SUNNICA ENERGY FARM

8.97 Applicant's Response to LPA Deadline 6 Submissions

8.97 Applicant's Response to LPA Deadline 6 Submissions

2.1 Interested party – Cambridgeshire County Council – D5

VEHICLE BODY	VEHICLE BODY PATH	VEHICLE WHEELS PATH
--------------	-------------------	---------------------

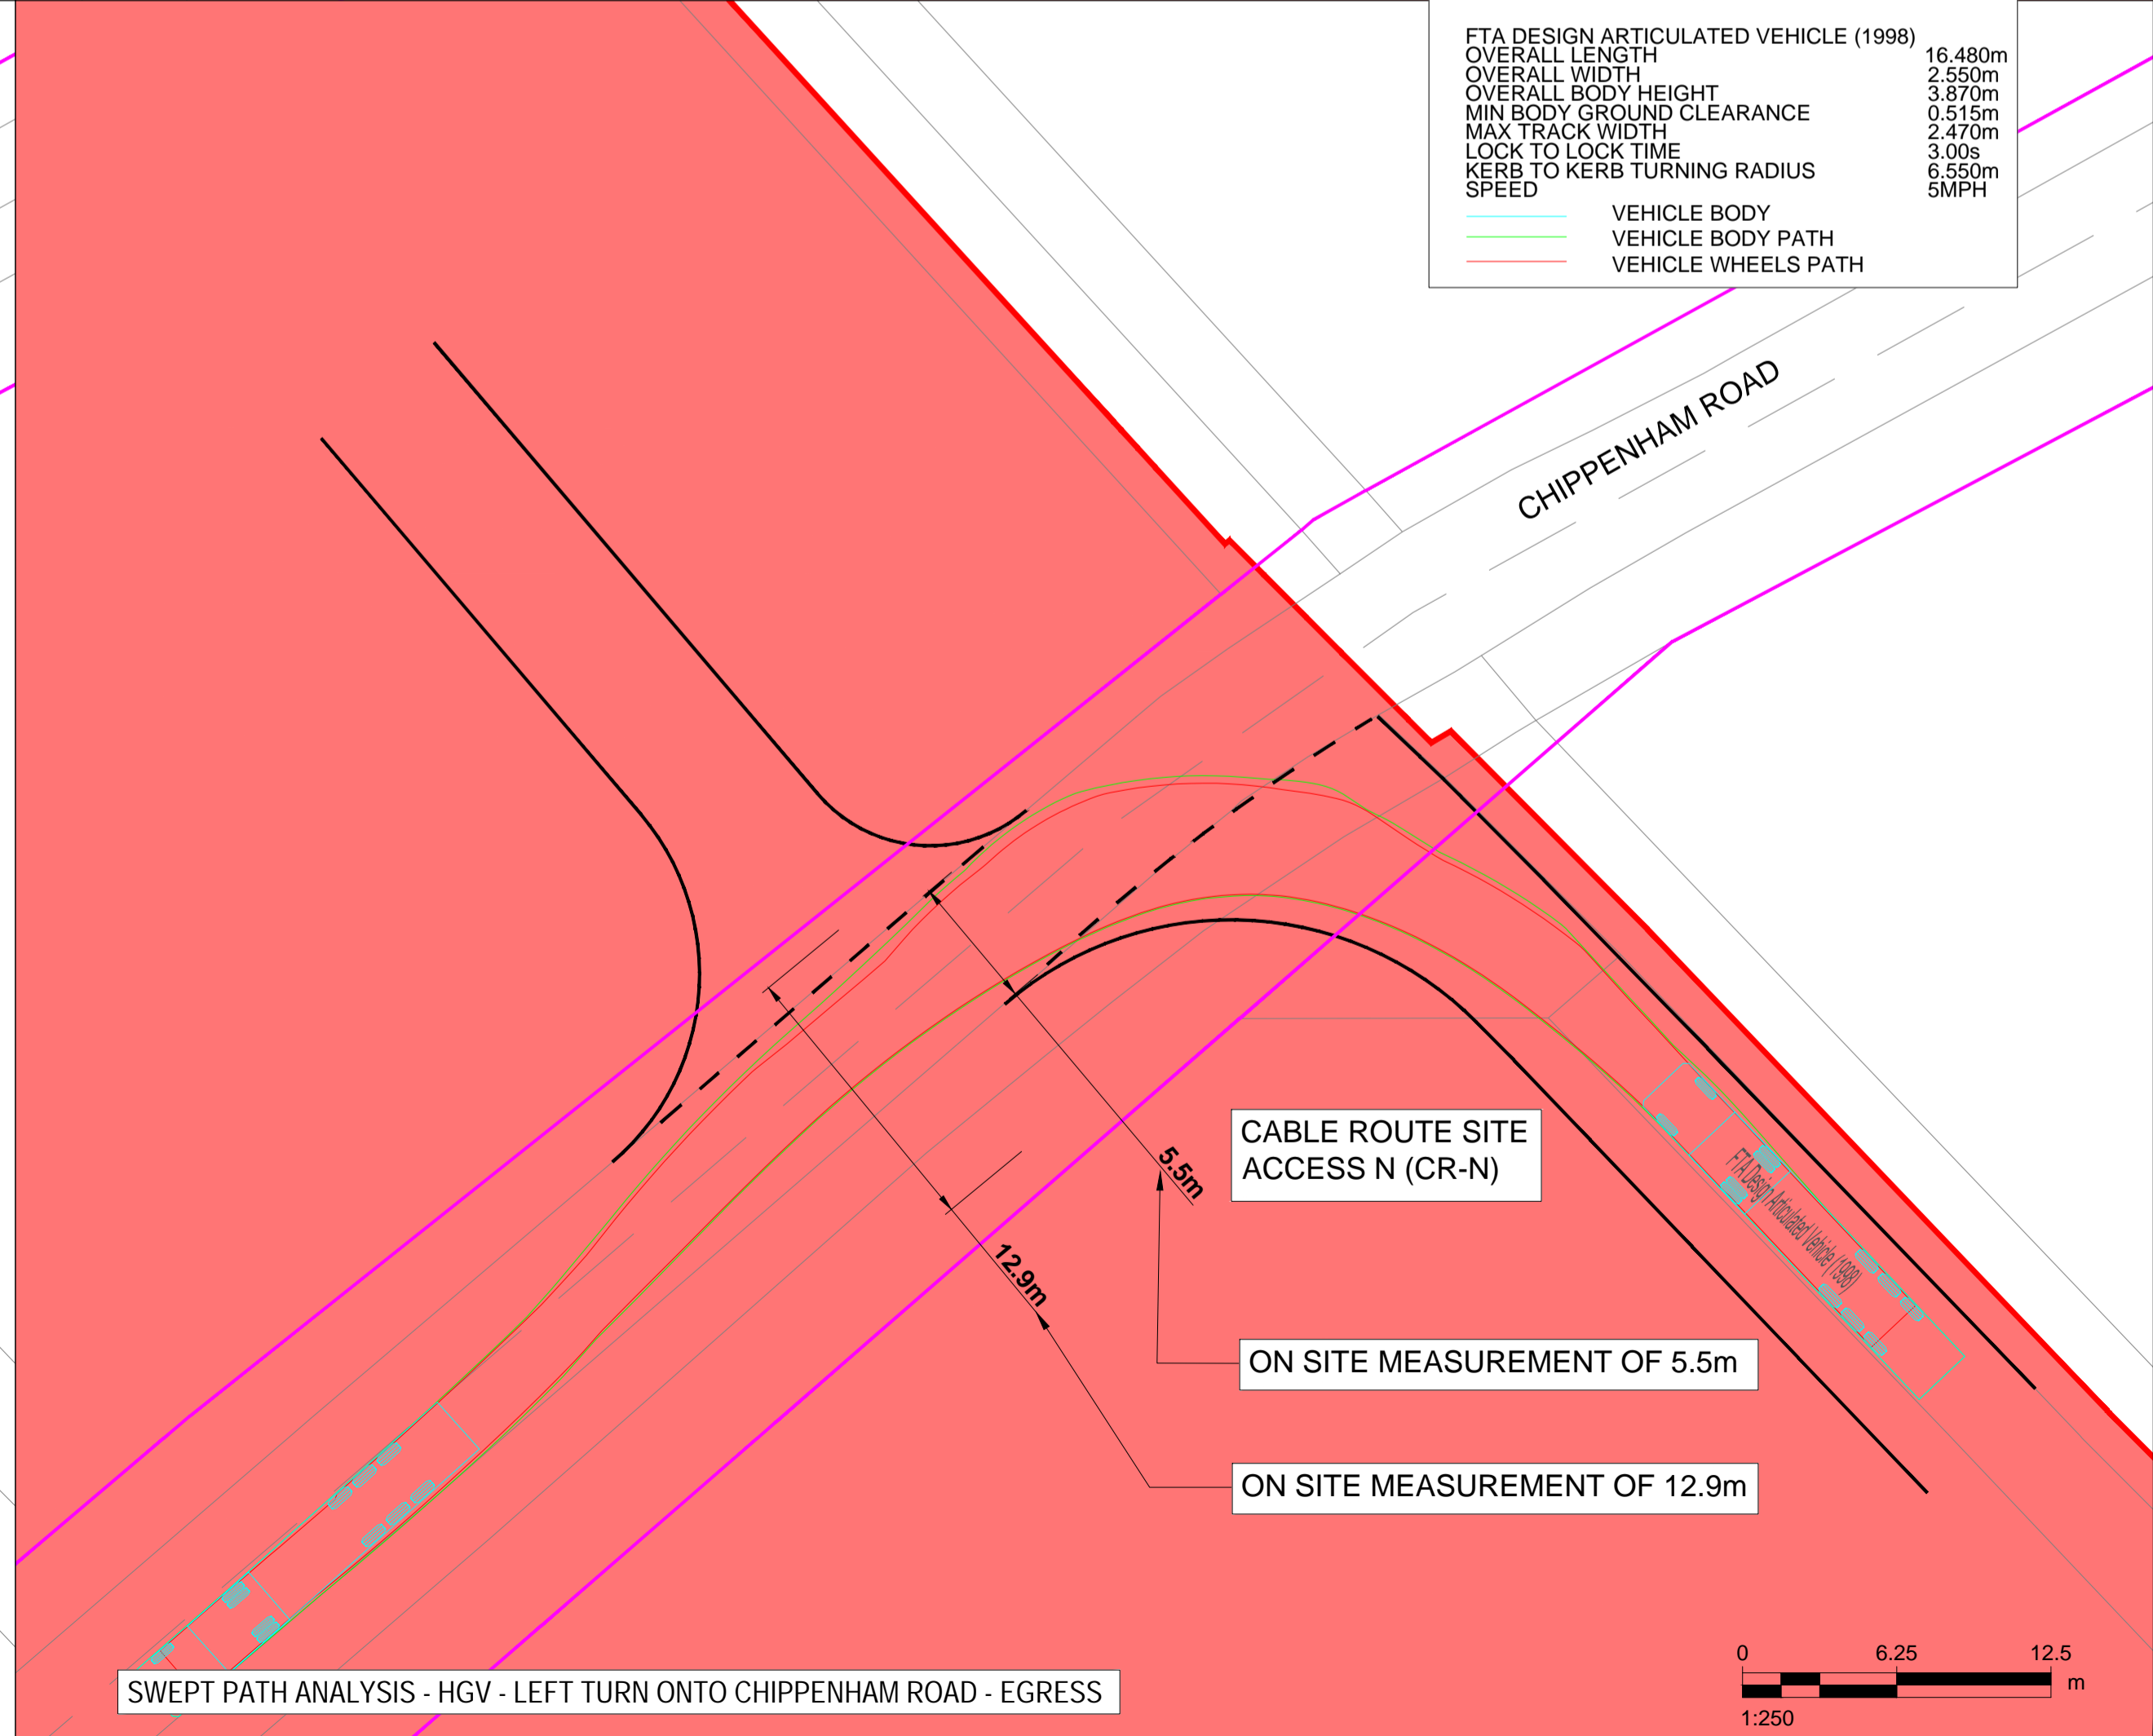
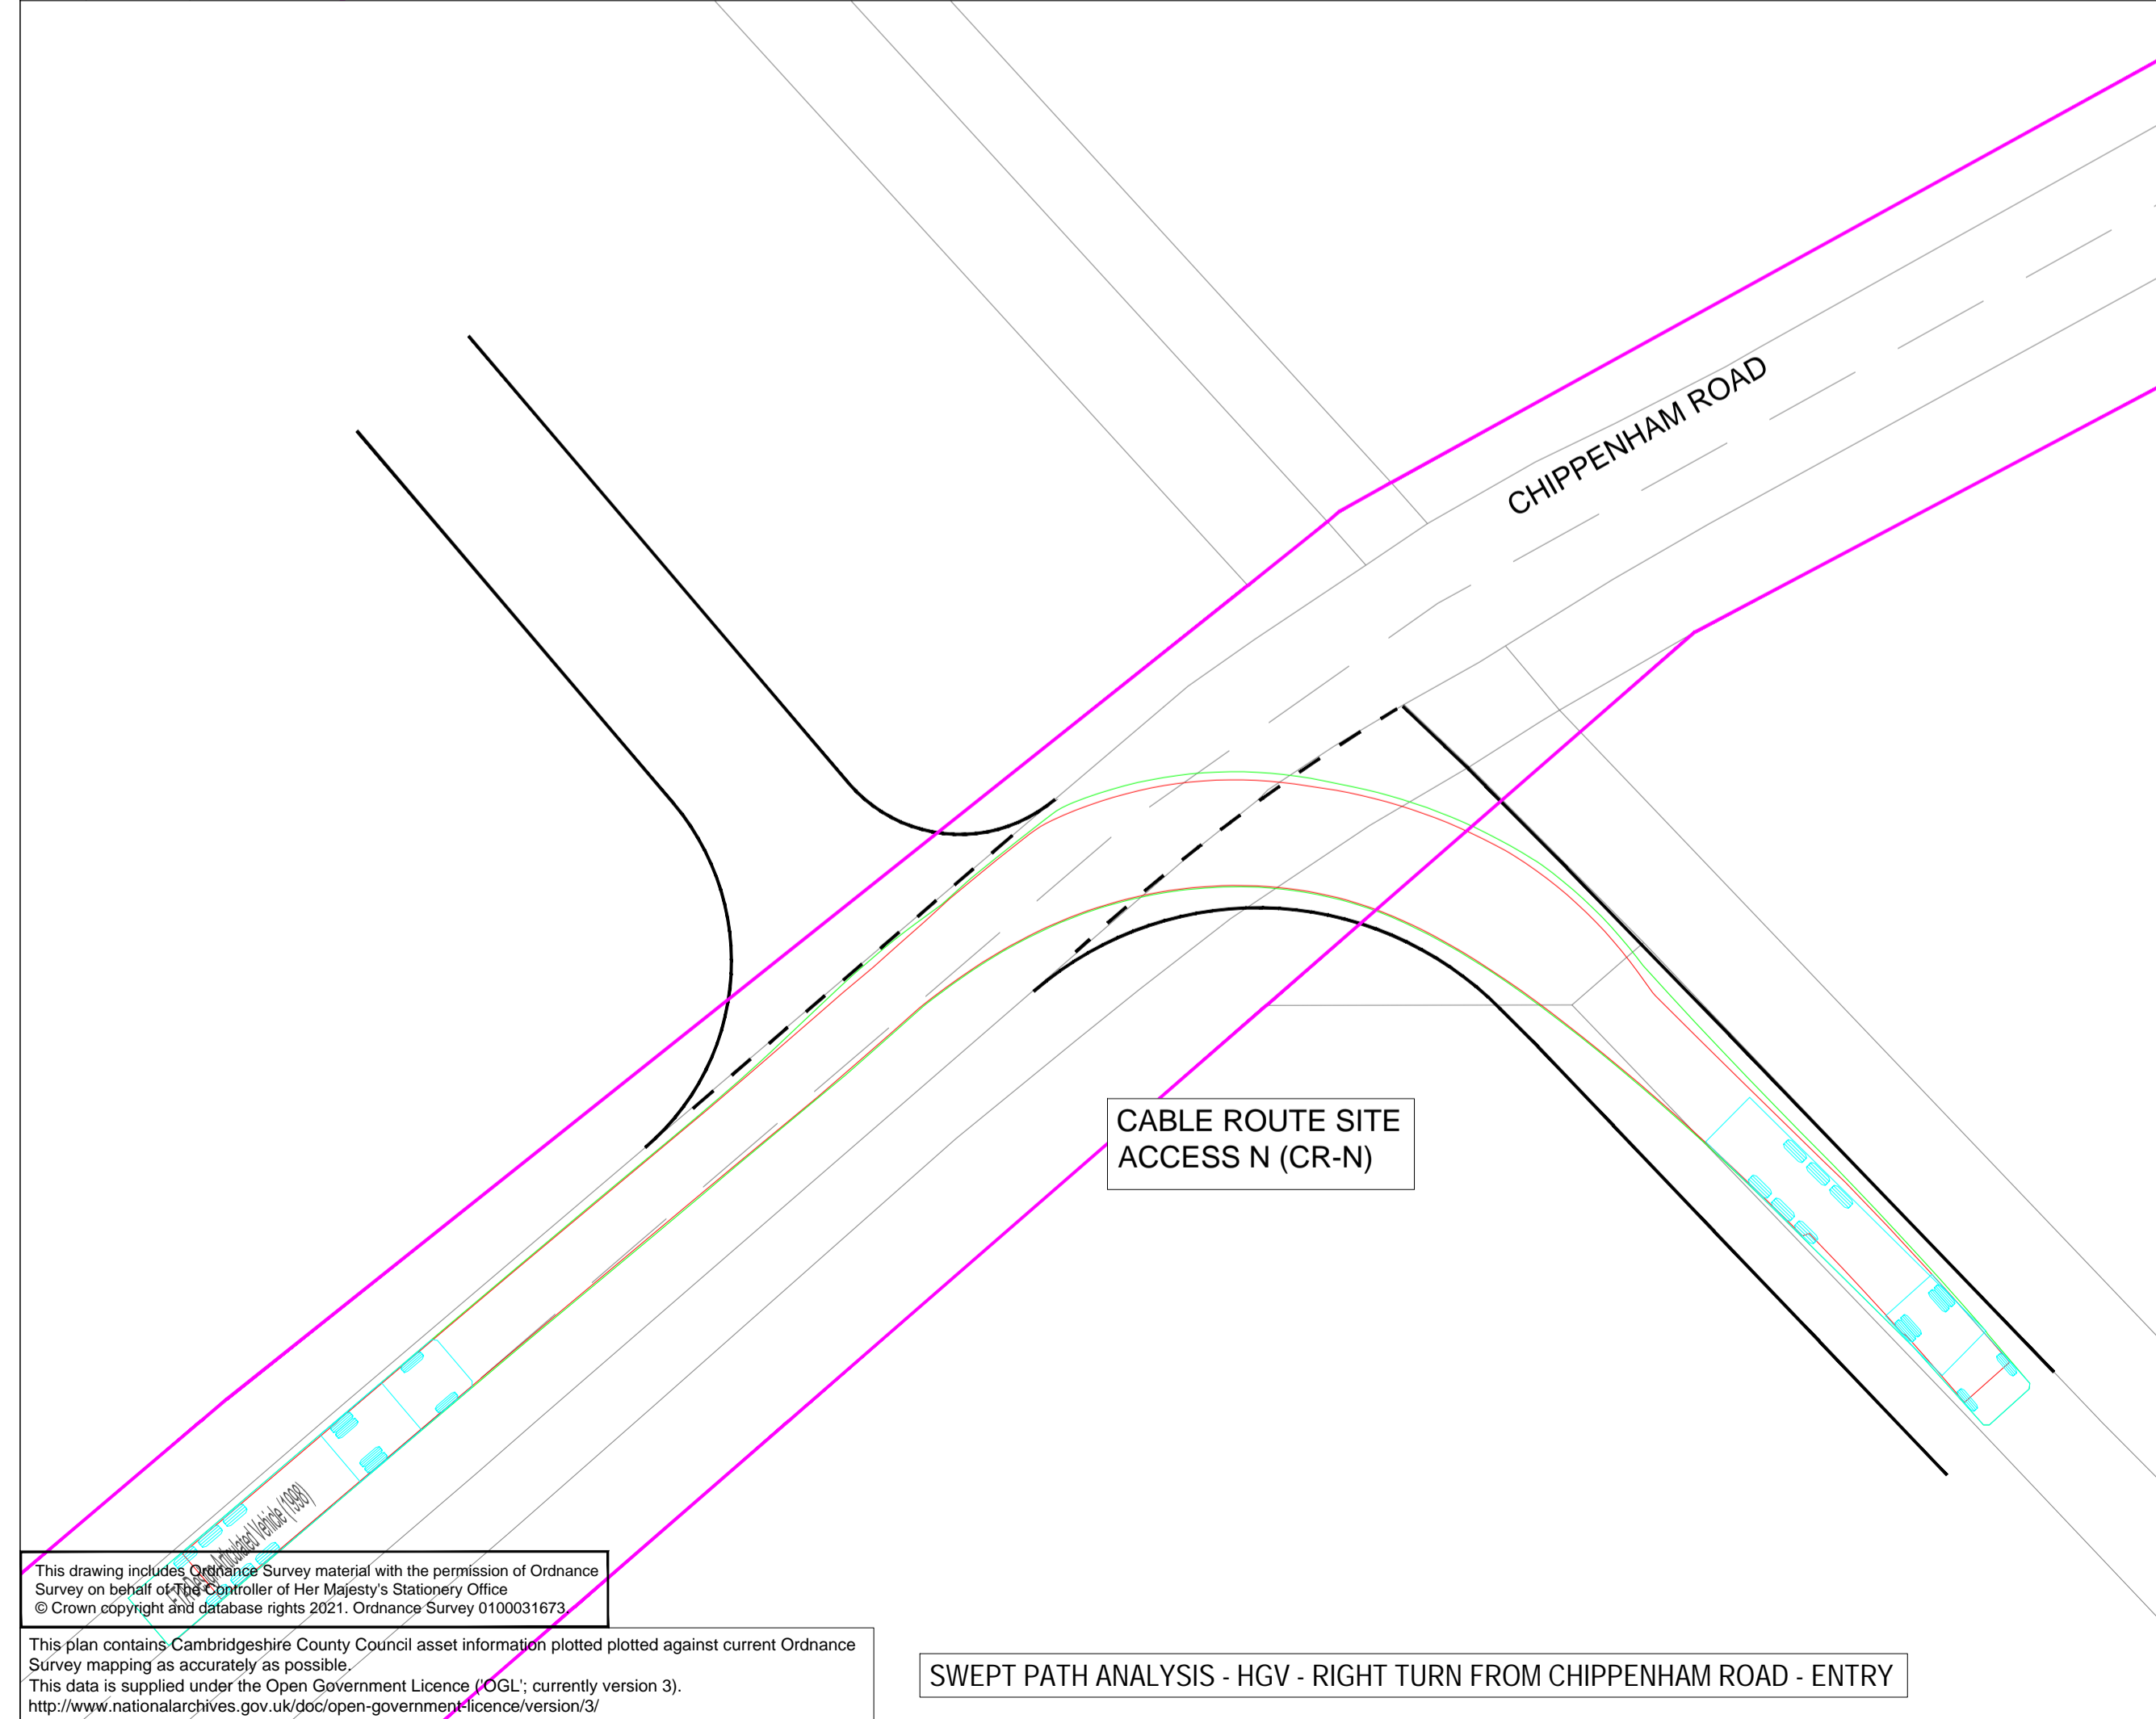
Topic	Deadline and Document Ref	Summary of issue raised	Applicant Response
			safe and suitable access can be achieved in any eventuality.
Plan ACM-60589004-AMR-DR-0038	Cable Route Access N. Snailwell Road, Chippenham.	<p>The proposal is to utilise an existing unmade field access, with improvements including 14m radius to the east but no radius to the west. This would not be considered acceptable unless it can be proven that traffic will not enter the access from the east during any phase of its use. It is also noted that any radius on the eastern side would conflict with an adjacent access and any proposal would therefore need to accommodate this.</p> <p>The swept path detail shown does not demonstrate the ability for two vehicles to pass, and while vehicle movements will be managed during the operational phase to avoid opposing flows, it is unclear how the access will be used during the operational phase, or how such conflict will then be managed. It is therefore unclear whether safe access is provided.</p> <p>No visibility splays have been detailed to demonstrate that visibility appropriate to the speed of the road can be achieved within the DCO or Highway boundary. Chippenham Road is planted with low trees to the west and with a dense hedge to the east, creating a significant risks obstruction of visibility; this is of particular concern to the east, with this access located on the inside of the bend. It is not therefore possible to confirm that safe access can be achieved</p>	<p>The Site Access Drawings in Annex C of the Framework Construction Traffic Management Plan [REP5-015] will be updated at Deadline 7. Access radii are shown on the plans, which demonstrate that swept path analysis of vehicles can be accommodated. For clarity, the radius on the plan is to the west, not the east as per CCC's comment. No construction traffic will enter from the east, as is secured through the HGV routes. The surface construction is a matter for detailed design stage of the project. Other comments relating to detailed design are noted and will be addressed at the appropriate design stage of the project.</p> <p>The Applicant's response to EXQ3.9.9 includes a table further demonstrating that there will be no intensification of use of this access in the operational phase. Thus retention of the existing field access in its current form is appropriate for the operational phase. As is set out in response to EXQ3.9.9, there will be no requirement for Sunnica LGVs or HGVs to access the cable route sites, unless a fault is identified remotely. If a fault is identified, the Applicant will be required to agree access arrangements with the LHAs to ensure safe and suitable access. If required, the DCO powers enable the Applicant to re-introduce the Temporary Traffic Management applied during the construction phase. This provides confidence that safe and suitable access can be achieved in any eventuality.</p>
